***Section 96(1A) Modification Application
Assessment Report***

Modification to the retractable awnings

***Mandarin Club Ltd, 1 Dixon Street, Darling
Harbour***

DA 063-04-2009 MOD 1

Section S/01

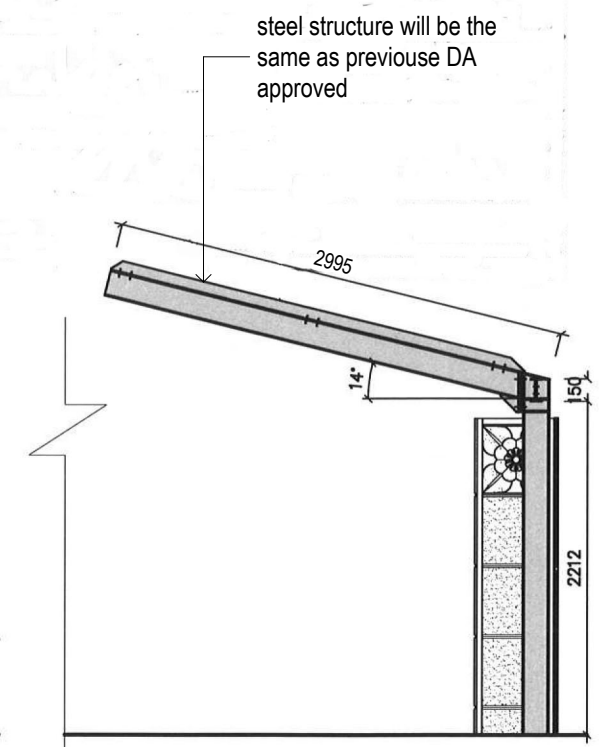
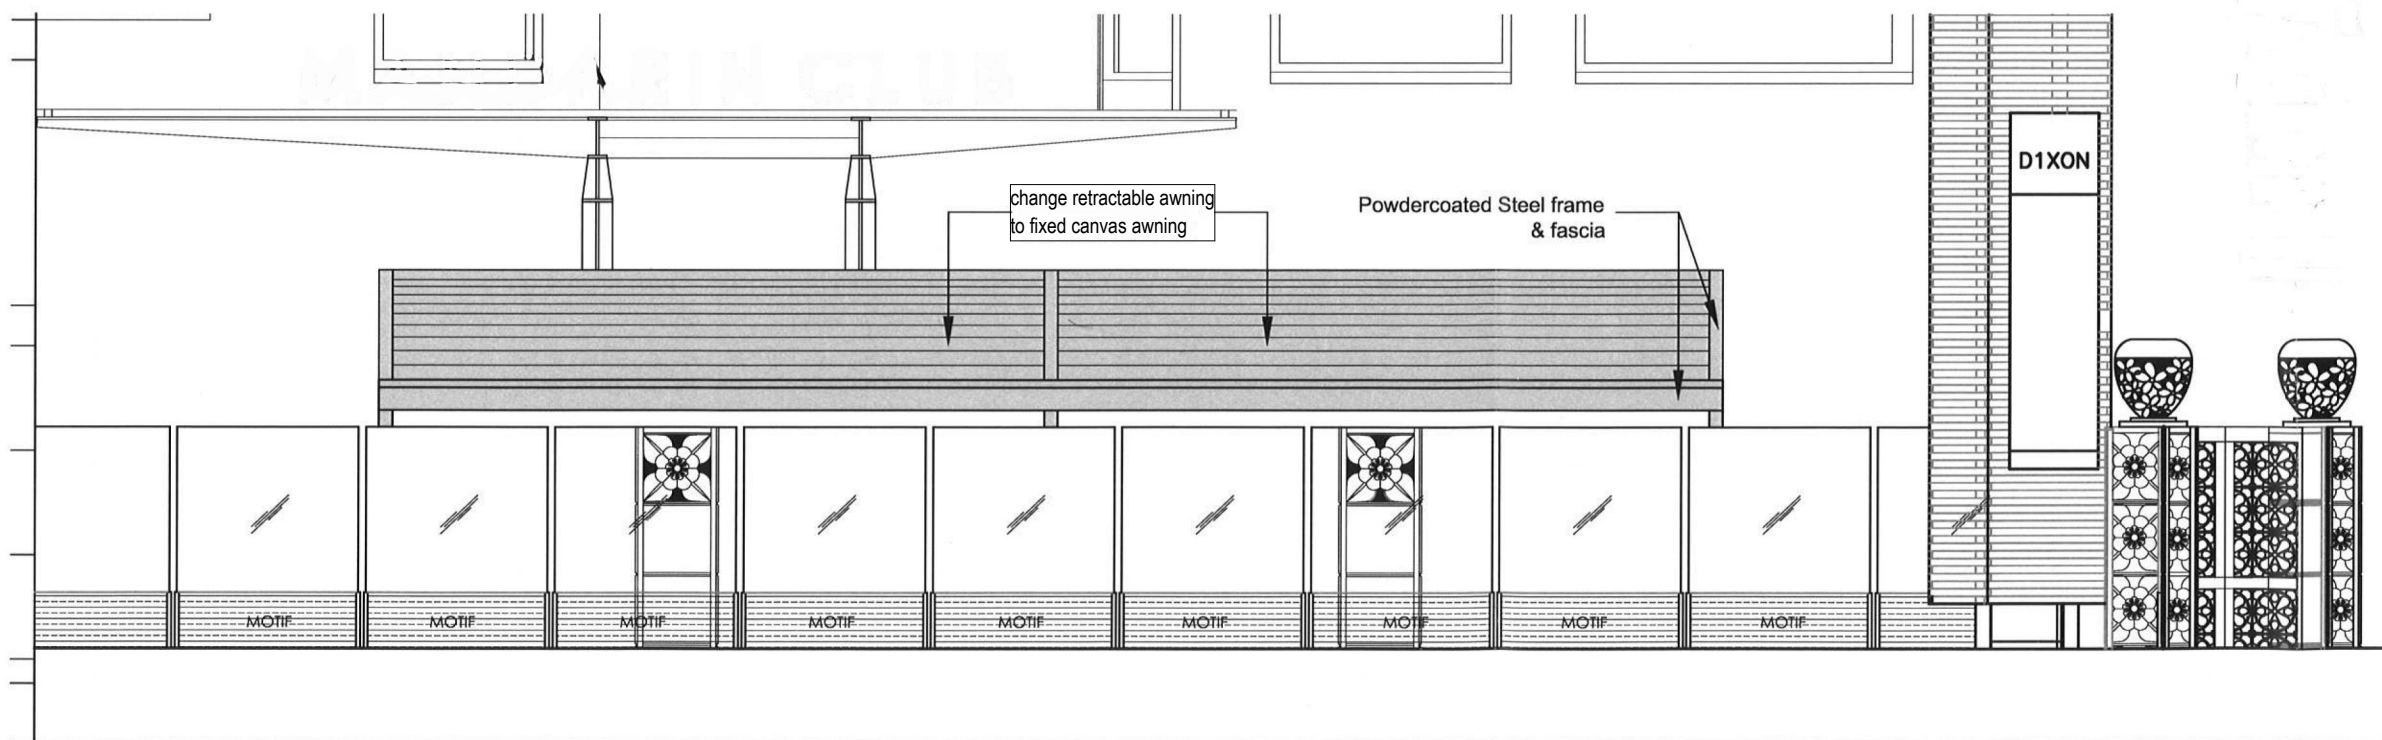
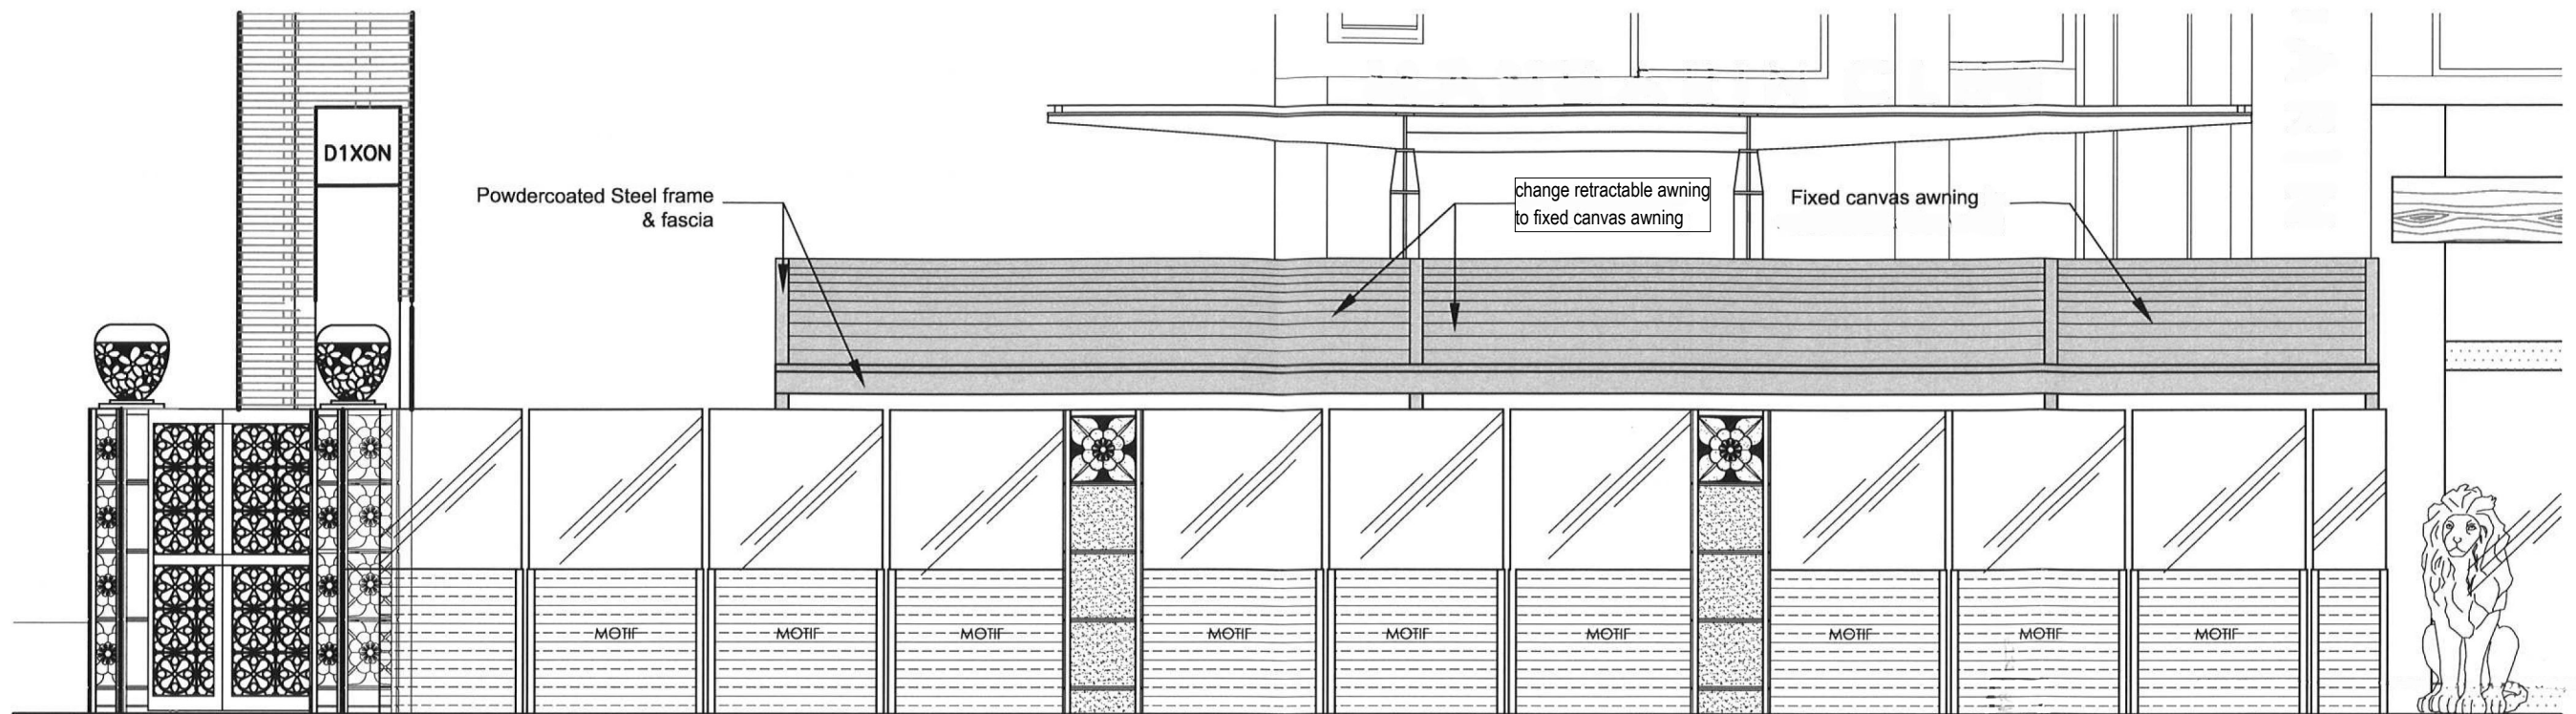
Upon lodgement of the modification request, the applicant also sought to change the material of the approved awning from canvas to polycarbonate. Section 2.9 of the City of Sydney Awnings Policy 2000 (awnings policy) states that polycarbonate awnings are not acceptable, as they are not sufficiently durable. As a result of the non-compliance, the applicant submitted revised plans that highlighted the material of the awnings will consist of canvas. This will also be consistent to the original approval.

The department considers the proposed modification acceptable as there will be no significant environmental impact. The awnings will remain the same shape and size, and the material is the same as the original canvas material. The canvas awnings are consistent with the council's awnings policy, and appropriate for the outdoor seating area of the Mandarin Club restaurant. The proposed awnings will provide greater weather protection to customers when in a fixed position. In addition, the awnings will have a minimal visual impact, as surrounding awnings in the area are not consistent in colour, material or style. The department therefore considers modification request appropriate.
